# Rezoning Transportation Analysis

Petition Number: 2022-117

**From: Jake Carpenter, PE**  
Jacob.carpenter@charlottenc.gov  
980-221-5675

Date	Description
12-28-22	First Review (TM)
1-24-23	Second Review (DR)

REZONING PLAN
RZ.01

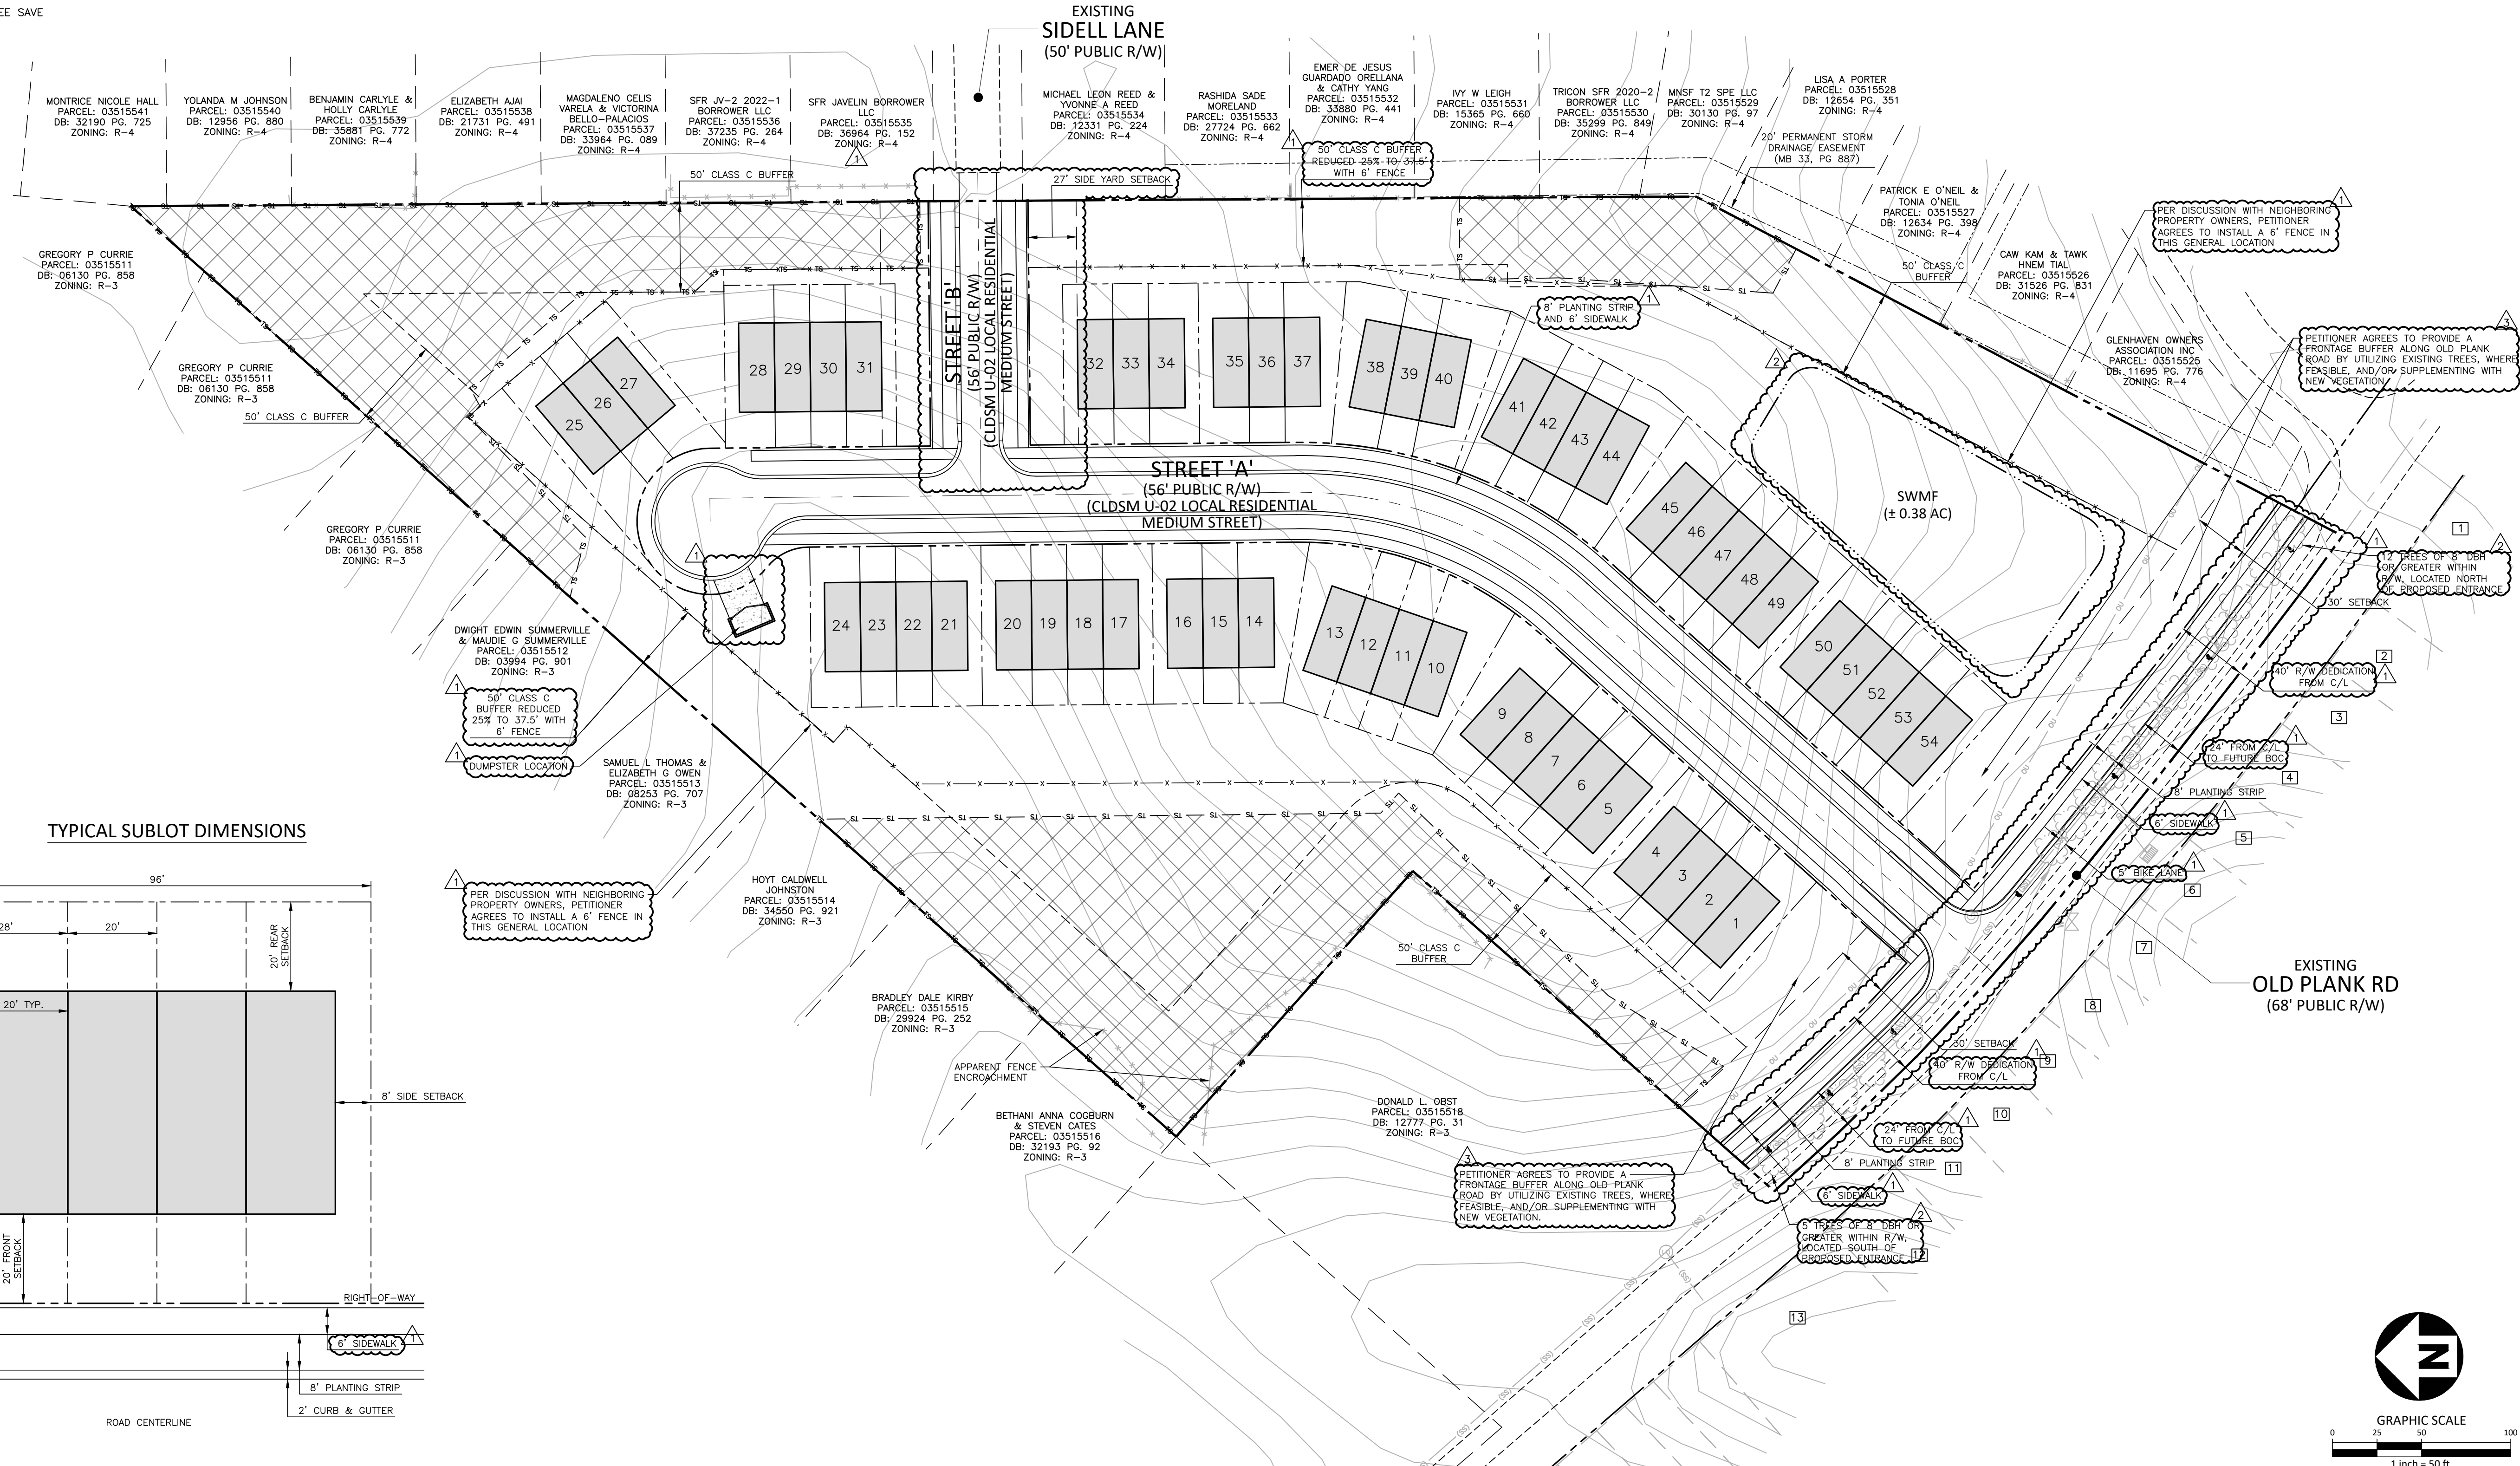
The petition is located on the east side of Old Plank Road, a City-maintained minor-throughfare south of Plumcrest Drive, a City-maintained local street. A Traffic Impact Study (TIS) is not required for this site due to the site generating less than 2500 daily trips. Site plan and/or revised conditional notes are needed related to SUE distance behind sidewalk. Further details are listed below.
